ADC PARKS & GREENSPACE ARBORICULTURE CONSULTATION

PLANNING APPLICATION: AW/114/12/T

ADDRESS: 10 Nuffield Close Bognor Regis PO21 5RA

BRIEF DESCRIPTION: Removal of 3 lower branches to 1 No Corsican Pine tree and removal of dead side branches to 2 No Corsican Pine trees

Map for PO21 5PU, PO21 5RA, PO21 5SJ

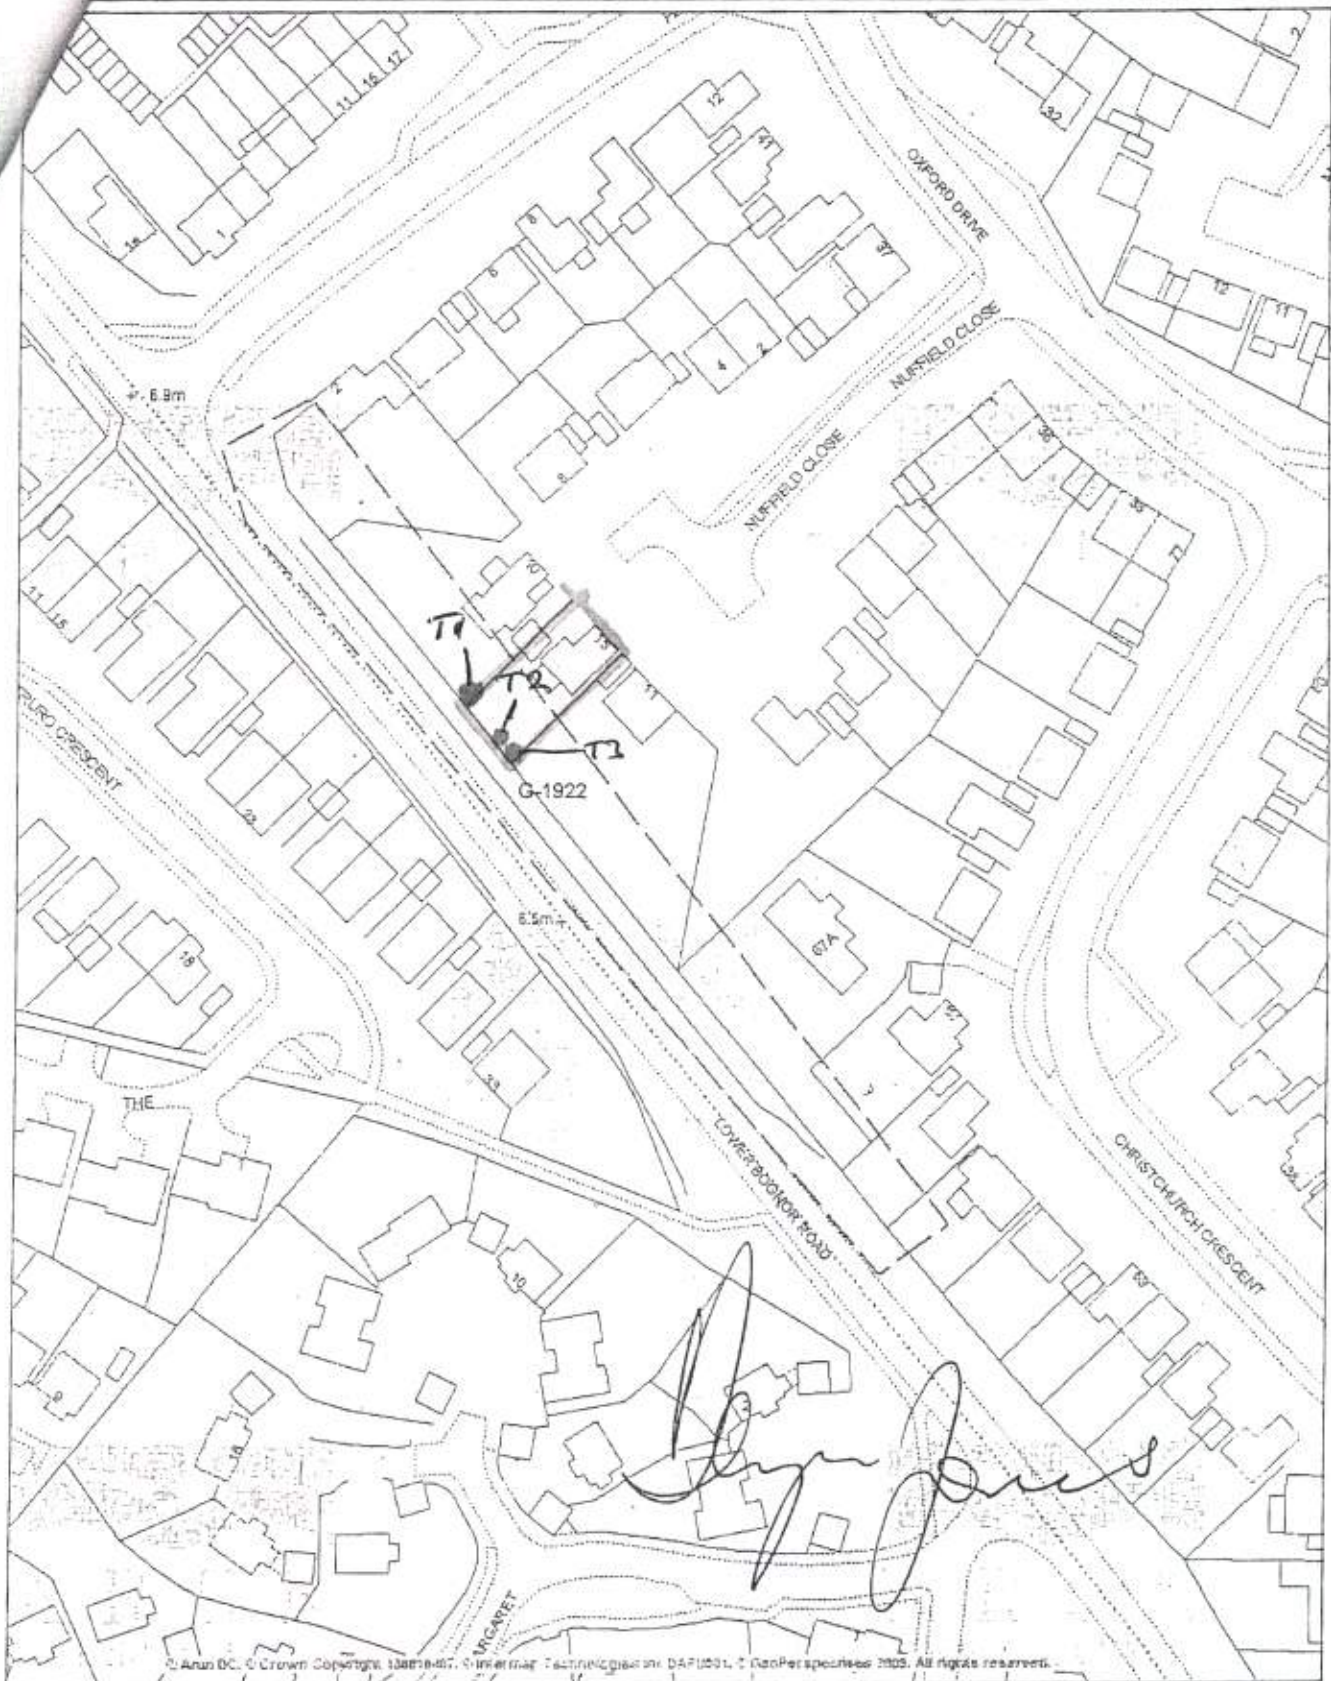
I have visited the site and identified the Pine tree shown as T1 on the applicants location plan. There are three limbs which hang low and partly over the applicants small shed. The removal of these three branches as pictured in the application would not be detrimental to the tree's health or detract from its visual amenity. If carried out to BS3998 (2010) as a Condition (see below), particularly in accordance with the principles of 'natural target' pruning, then I find the above work acceptable.

Condition: Branch Removal

- The top edge of the final pruning cut must be just outside of the basal flare of the branch being removed where it meets the main stem.
- The cut must be at right angles to the grain and direction of the branch.
- The pruning wound surface must be smooth.
- The pruning wound must be kept as small as possible.
